Medworth ISH2_12 April_PT2

FULL TRANSCRIPT (with timecode)

- Notes:
1. Proposed visibility based on New Bridge Lane being subject to a revised 30mph speed limit.
  2. New street lighting has been provided on an indicative basis (at 30m intervals and at conflict areas) and will require detailed design and assessment.

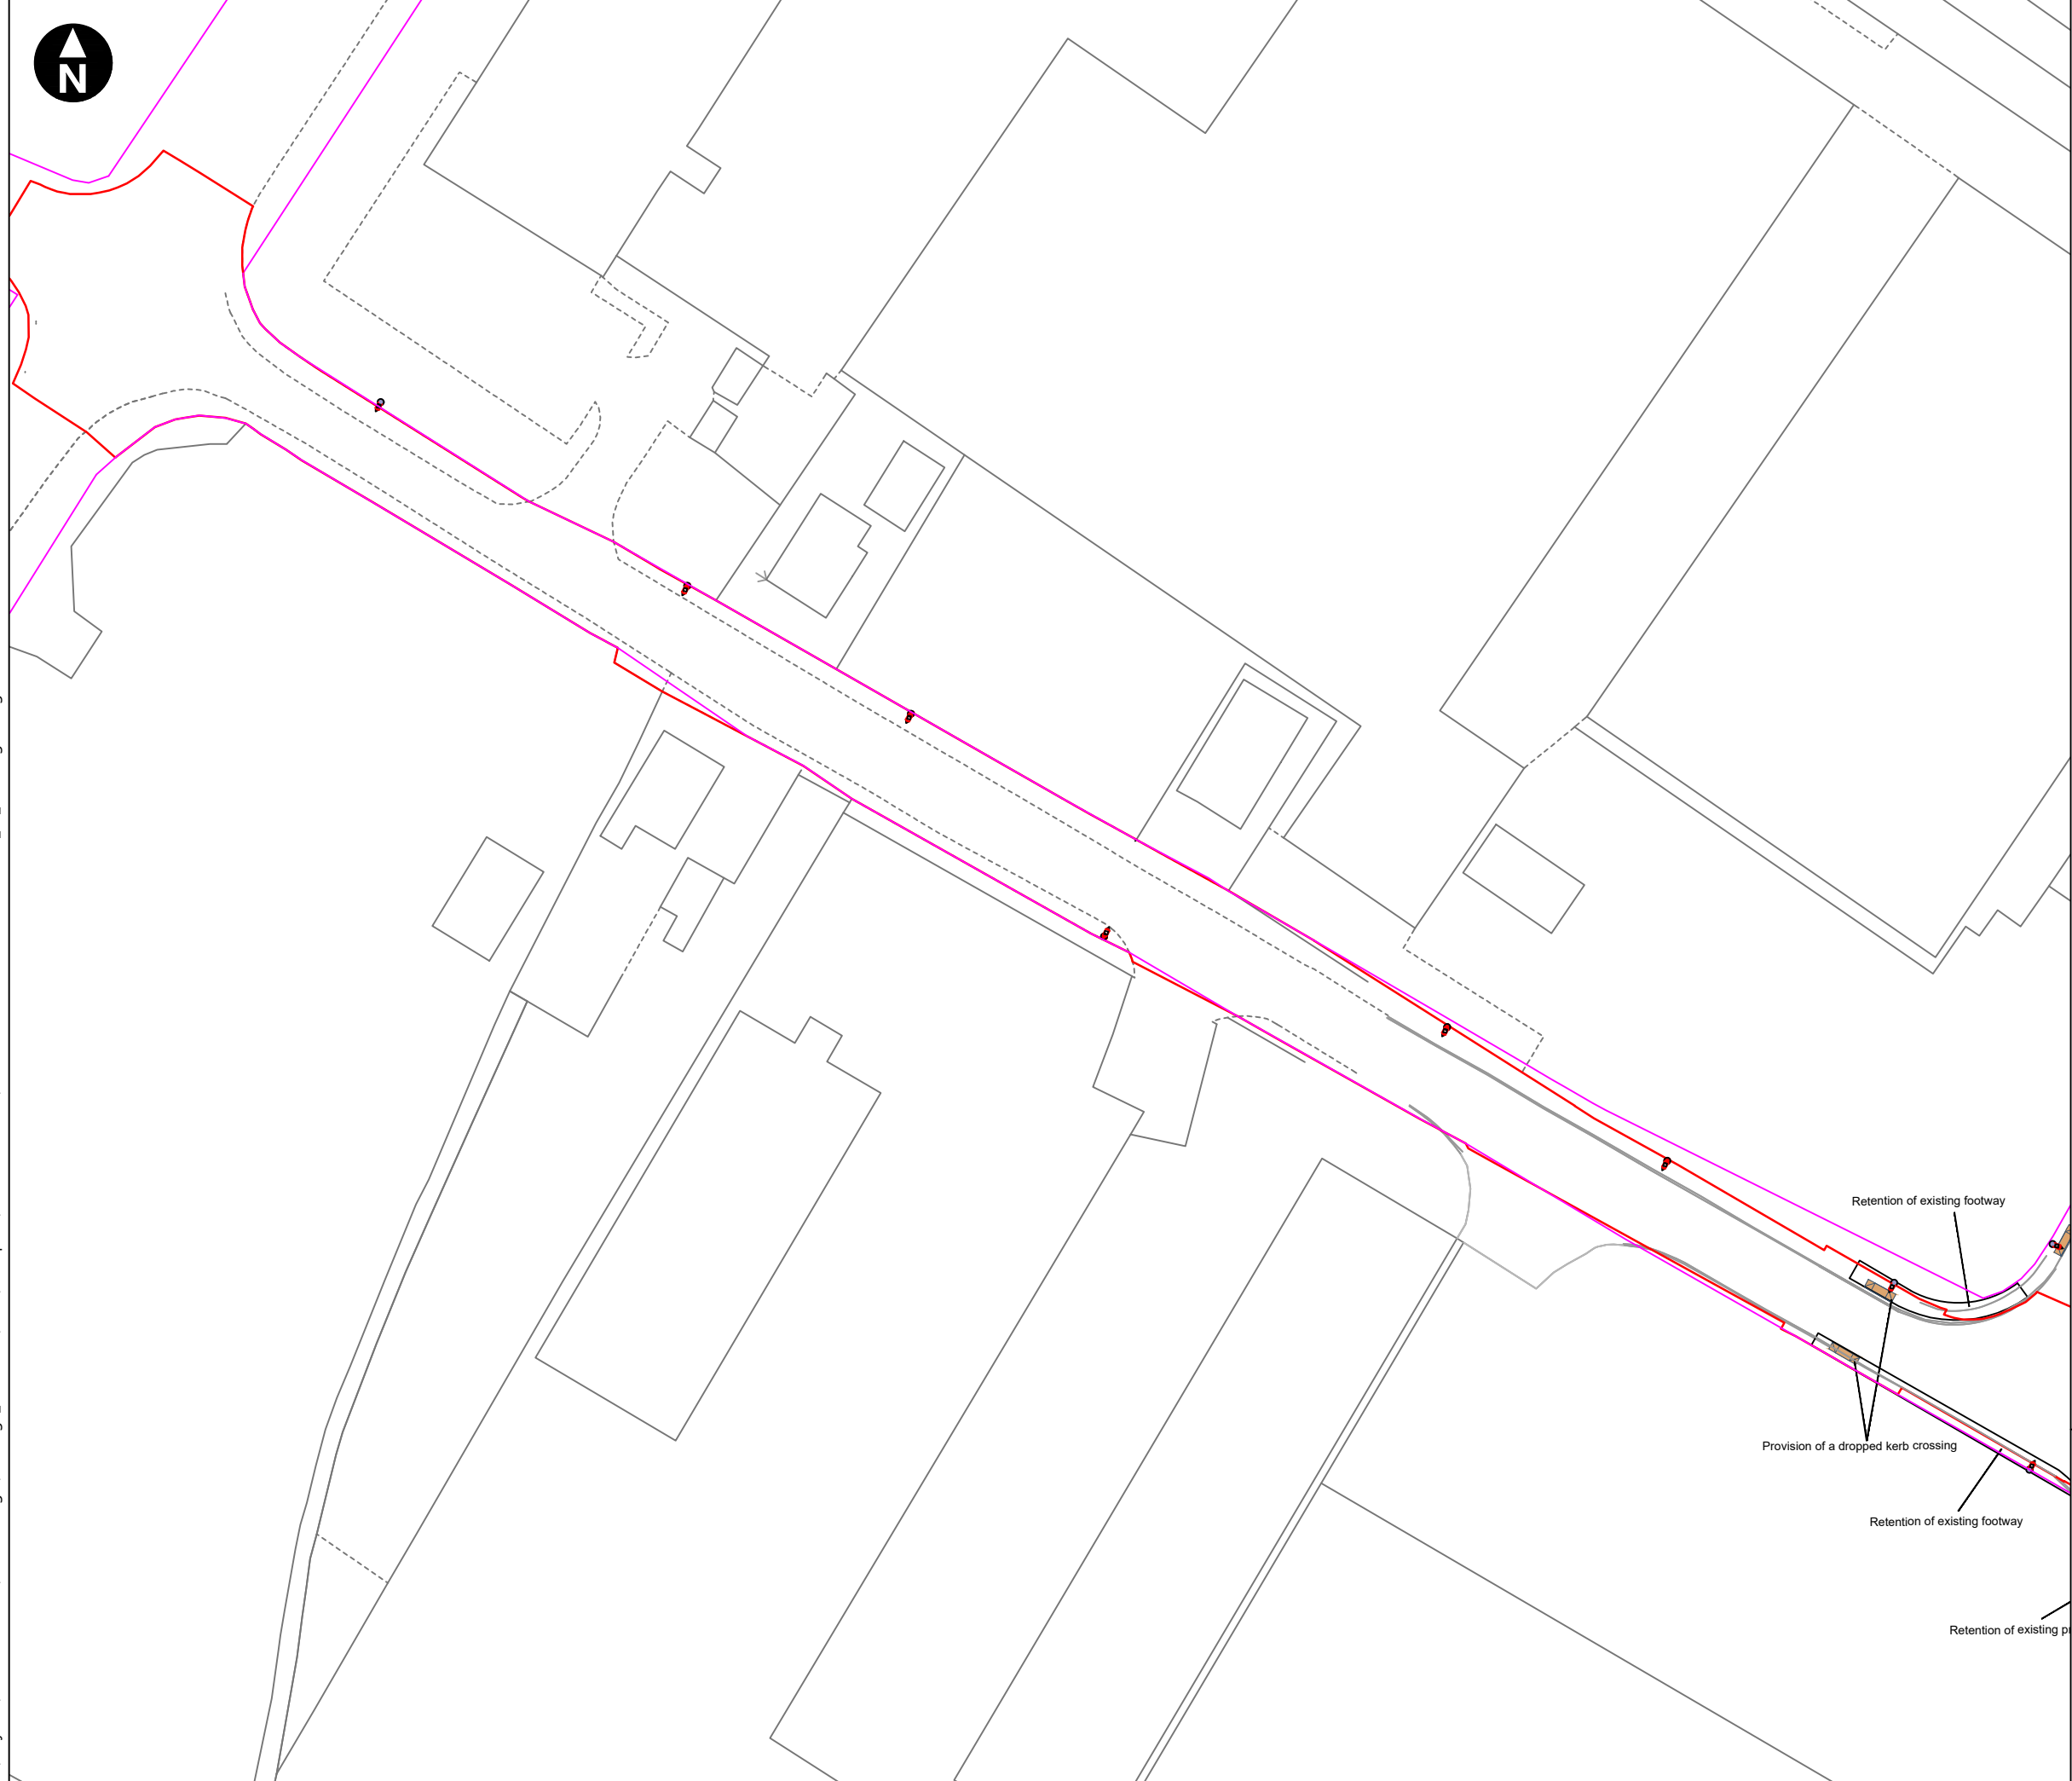
We regard this as quite an important issue because we think it does fundamentally affect the deliverability of the scheme, both with respect to new bridge lane and the widening of that and the provision of a safe and appropriate junction at the new bridge Lane Cromwell Road Junction. Now, I'm not gonna say any more about the substance of that, but that is an issue which we want to have the ability to contribute to. And if that's to be tomorrow, so be it. Um, I'm not available to attend tomorrow and I don't think my team can physically be here either.

That doesn't to me seem to cover the requirement to be involved in the design and approval of more substantial work, such as those on new Bridge Lane, which would be covered by Article 11 of the DCO. And that is a substantial reconstructing of a road which we would like to be properly protected when we're involved in.

It's not very clear on the screen. I was just trying to clarify that the hatched area that covers works for a doesn't cover the entire length of Newbridge Lane. It stops at a point slightly to the south, slightly to the southeast of the proposed site, but it doesn't go all the way down to the a47. That's the point I'm trying to make.

Article seven, schedule two highways access. Description. It's still only provides the most bare bones of control. Written details of the access improvements as part of the work we set out. Repeated in detail the more extensive control that we think is necessary. That's that's observation number one. Observation number two is a matter of drafting within the access vision that that article, which is that seven two.

Refers to submission to an approval by the relevant planning authority. Now, clearly it seems to me that needs to be amended to say the relevant highway was the authority.

For the applicant. I think Masako was being slightly unkind in his characterization of our response, if I may say so. The applicant in response to the concerns raised, did deadline one submit and updated figures showing the improvement works to Newbridge Lane and Al Gore's way and construction traffic management plan was updated. Outline plan was updated and submitted at deadline one with with additional detail around the process and commitments around engagement and consultation with the Cambridgeshire.

Misleading as a result of the way that the requirement is titled Highway access. But the intention of Part two of requirement seven is to cover all of the totality of the improvement works captured by what number four and four be. So new bridge lane. And our goals are not just specific accesses, so stop paragraph one deals with new accesses and paragraph two is intended to deal with improvement works to new bridge lane. And of course we hope that's helpful.

For the applicant. Yes. So we're happy to try and provide some clearer figures. What we might be able to do is to separate out the layers so you're not seeing all the layers over there.
